Our ref: AN/2024/135560/03-L01
Your ref: EN010130
Date: 24 October 2024

Application by GT R4 Limited (trading as Outer Dowsing Offshore Wind) for an order granting development consent for the Outer Dowsing Offshore Wind Project (Generating station and transmission infrastructure)

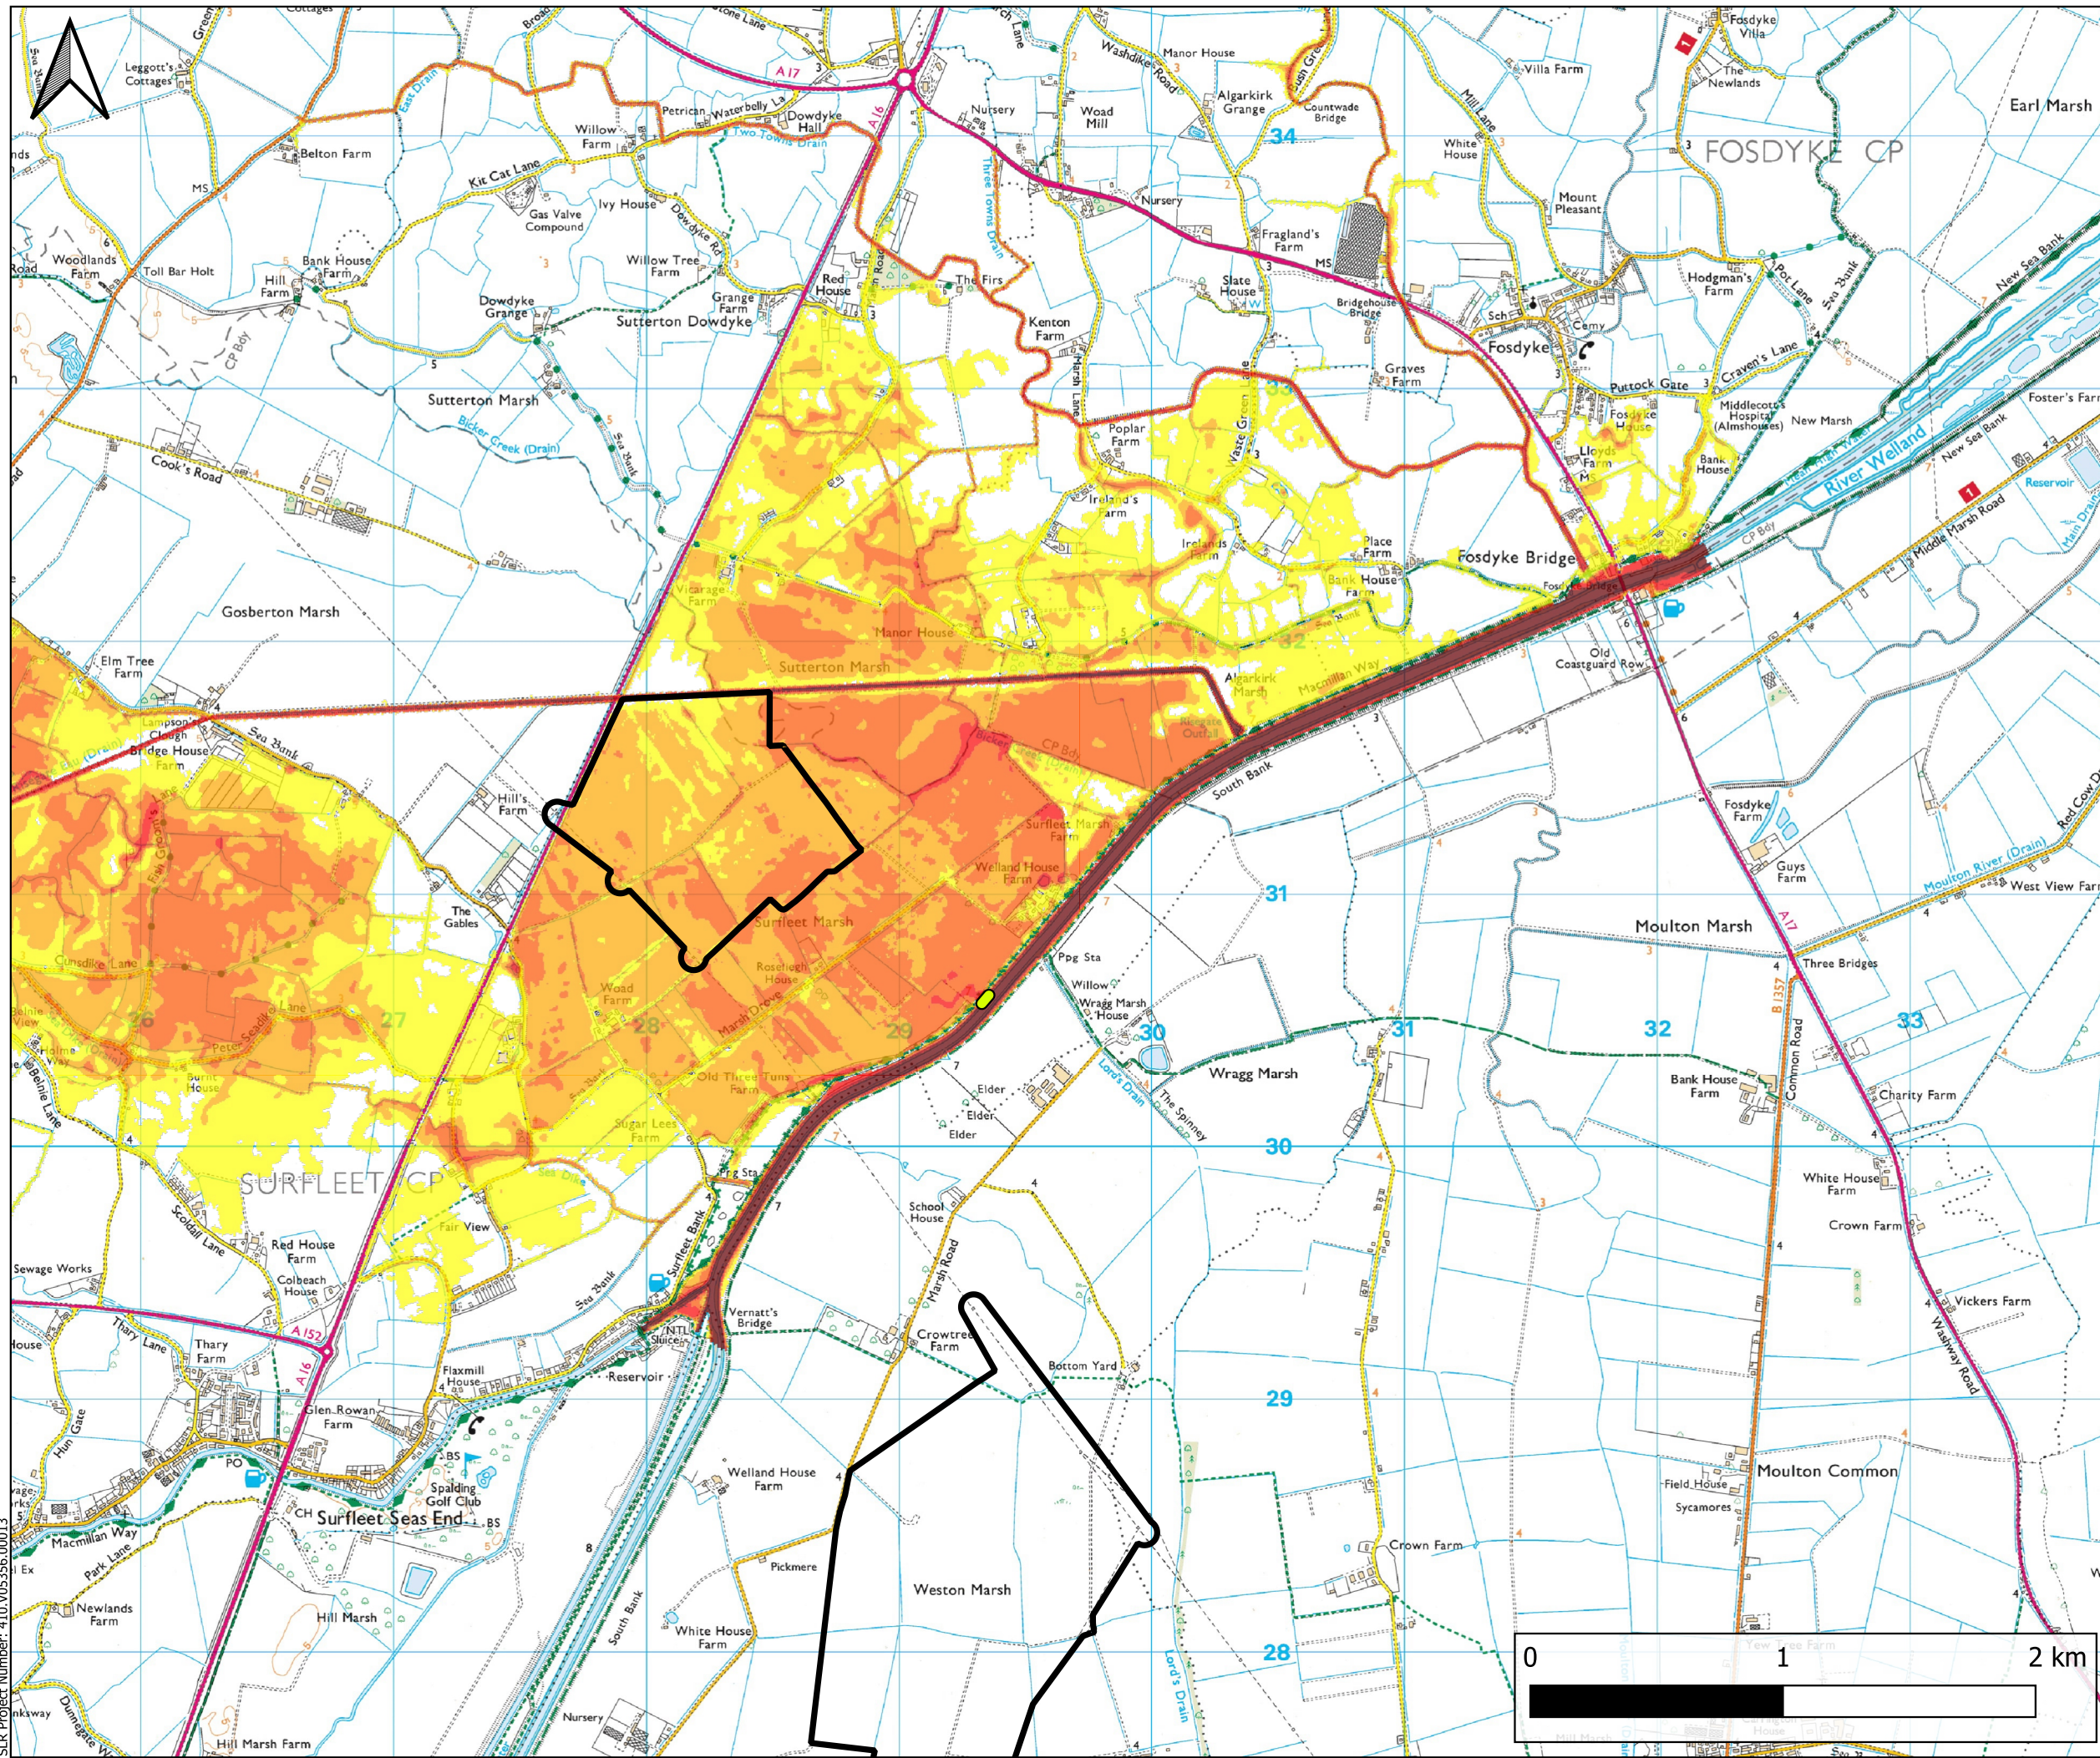
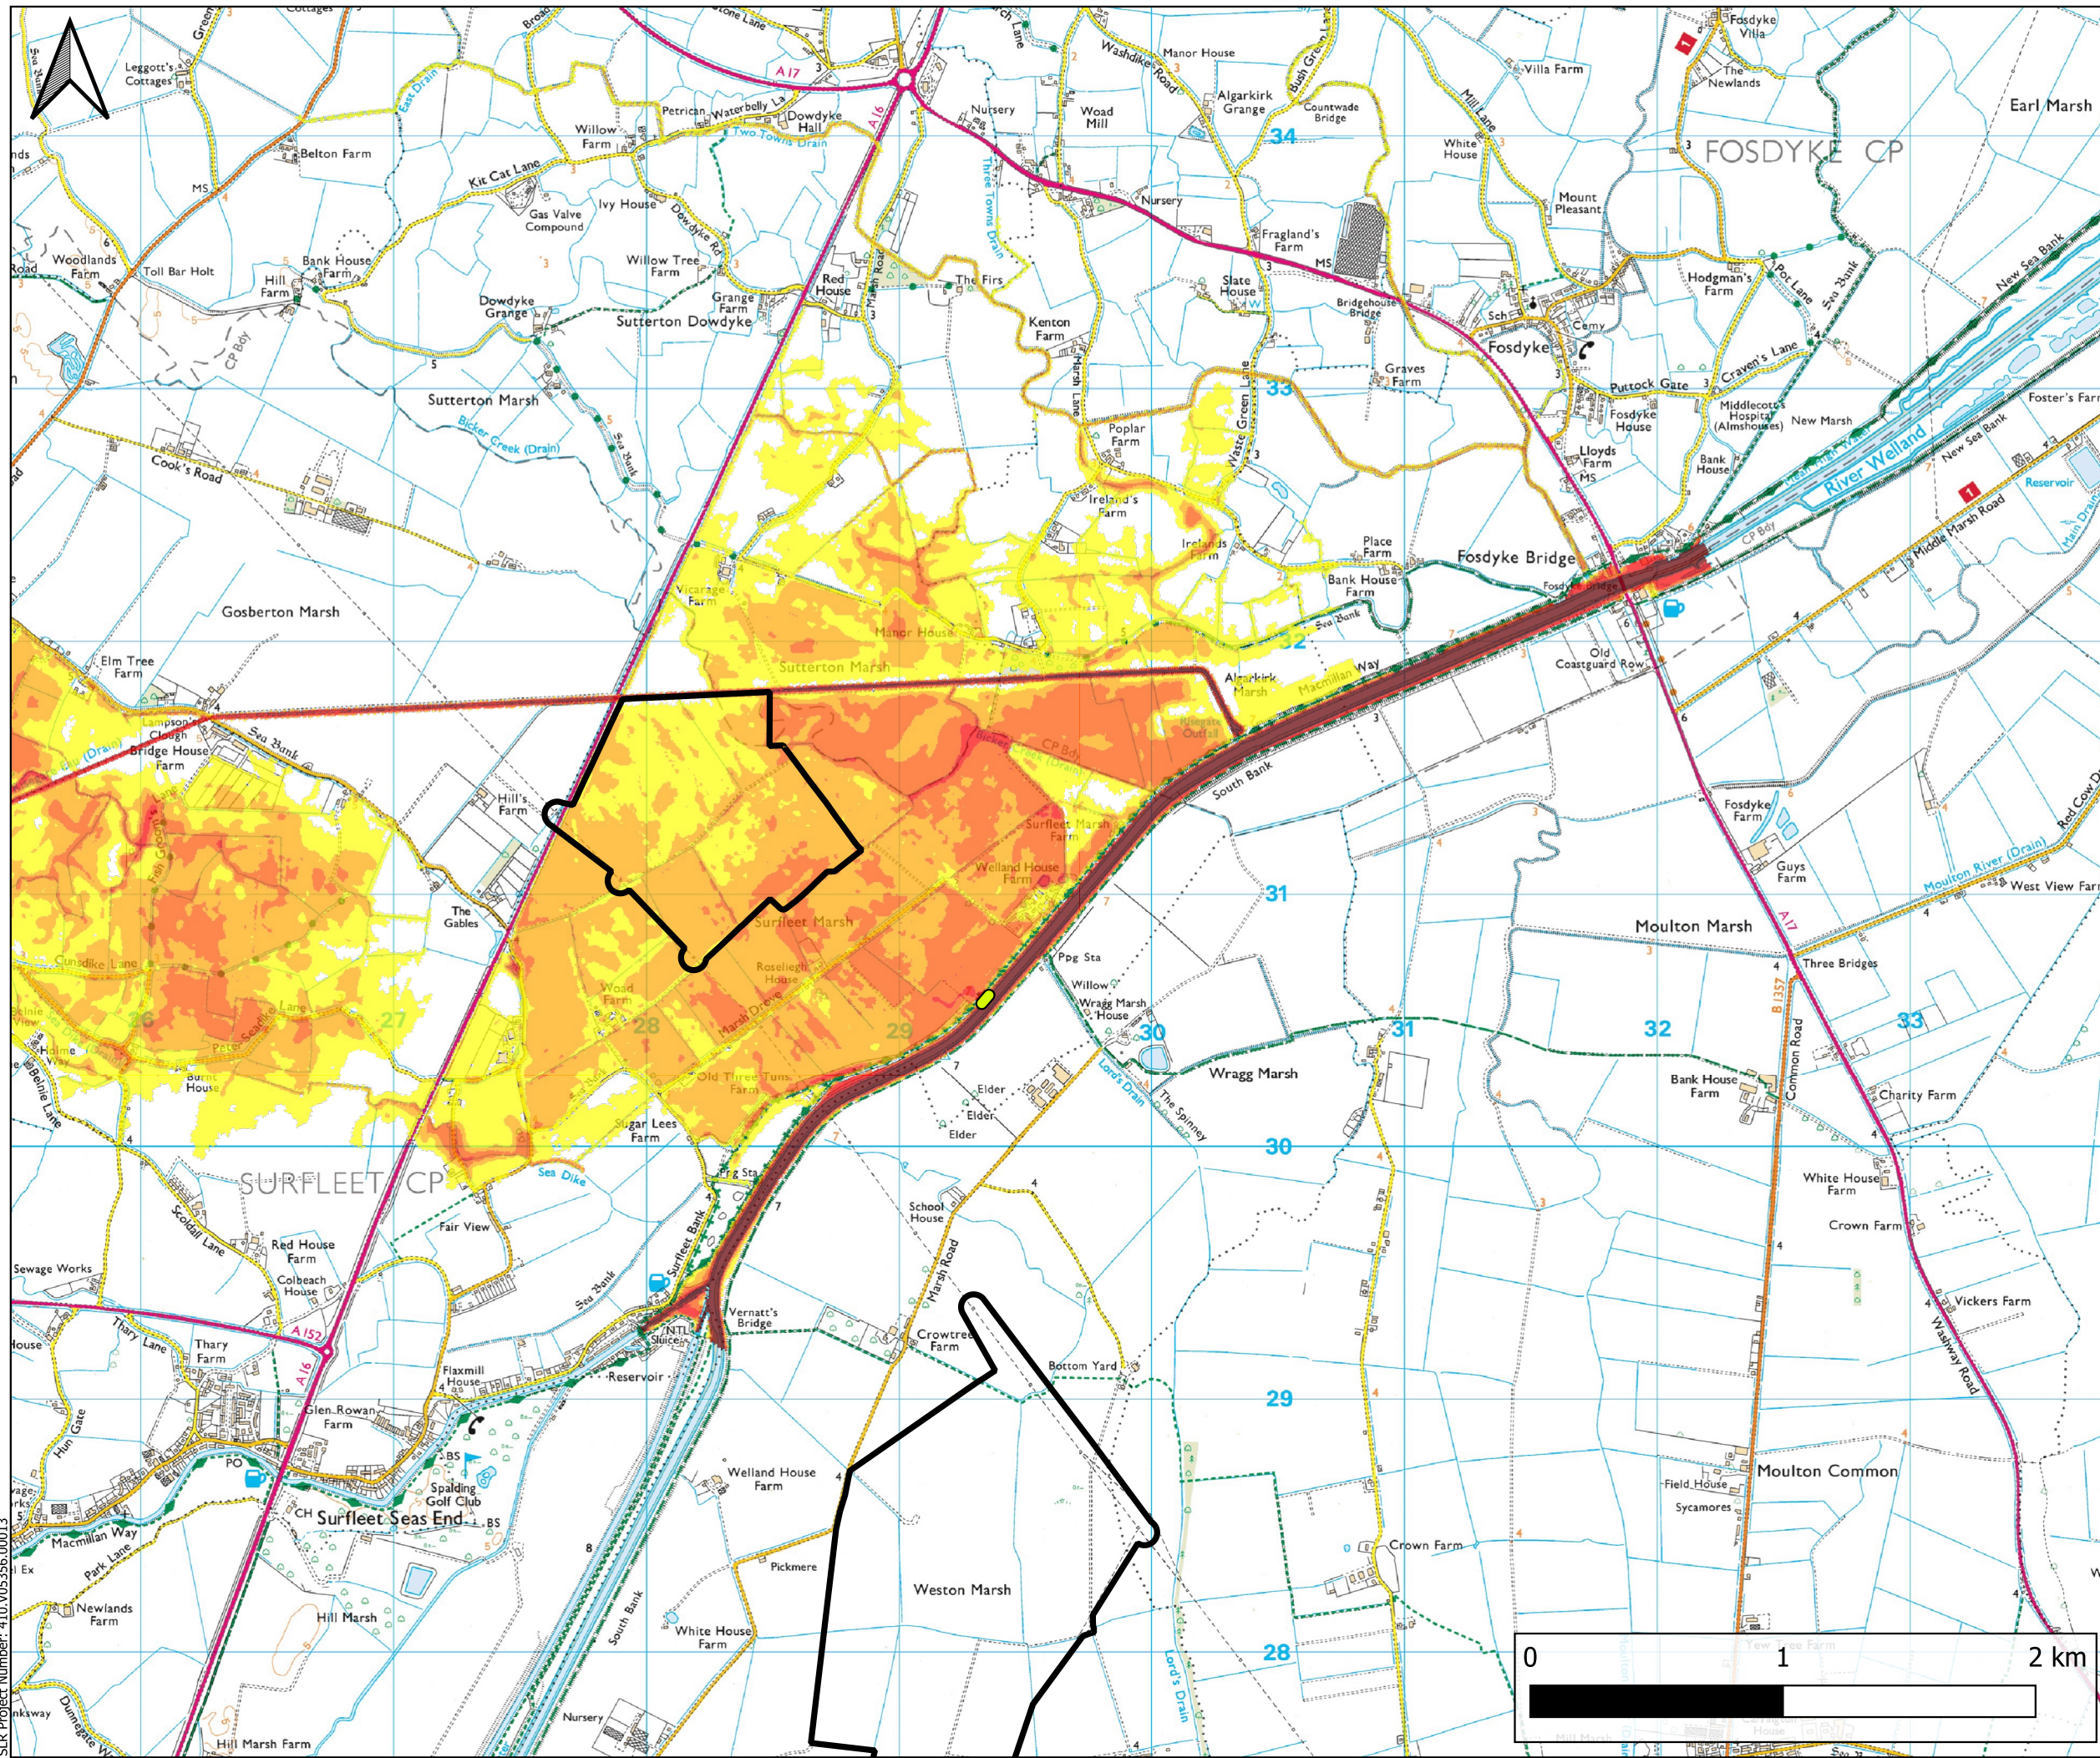
- 8.0 **Chapter 24 Flood Risk; Chapter 24 Appendix 3 Flood Risk Assessment Onshore Substation (OnSS)**
- 8.1 **Hydraulic modelling of the OnSS** – The Applicant provided an updated version of the River Welland Breach Modelling (Version 3) to the Environment Agency on

25 July 2024. We undertook a review of this, but there are queries that still need to be addressed – these were communicated to the Applicant on 10 September 2024, and we are currently awaiting a response to these. Therefore, we are not yet able to provide any further advice on this matter.

- 8.4 The FRA has not considered (or assessed) the potential scenario that the OnSS may remain in place beyond the 35-year design life in relation to the impact on 3rd parties and climate change. As the OnSS is to be built on a raised platform the Applicant must assess whether this land raising will increase the risk of flooding elsewhere. The assessment can only be limited to the 35-year design life if it is accompanied by a Requirement that the OnSS is decommissioned in 2065, and the land returned to its original level – there is currently no requirement in the DCO to ensure this happens. Without such a decommissioning requirement there is a chance that the OnSS may remain operational beyond its 35-year design life (component parts may be renewed/replaced) and the impacts of this on 3rd parties have not been assessed.

- 8.7 In line with the above policy requirements, the Environment Agency requests that the Applicant either carries out an assessment of the raised platform and OnSS remaining in place beyond 2065 (using at least 75 years to form a starting point) and in particular the impact this will have on 3rd parties in relation to climate change. Alternatively, the DCO must include a requirement to ensure the OnSS is fully decommissioned in 2065 and the land restored to its original, pre-construction, level.
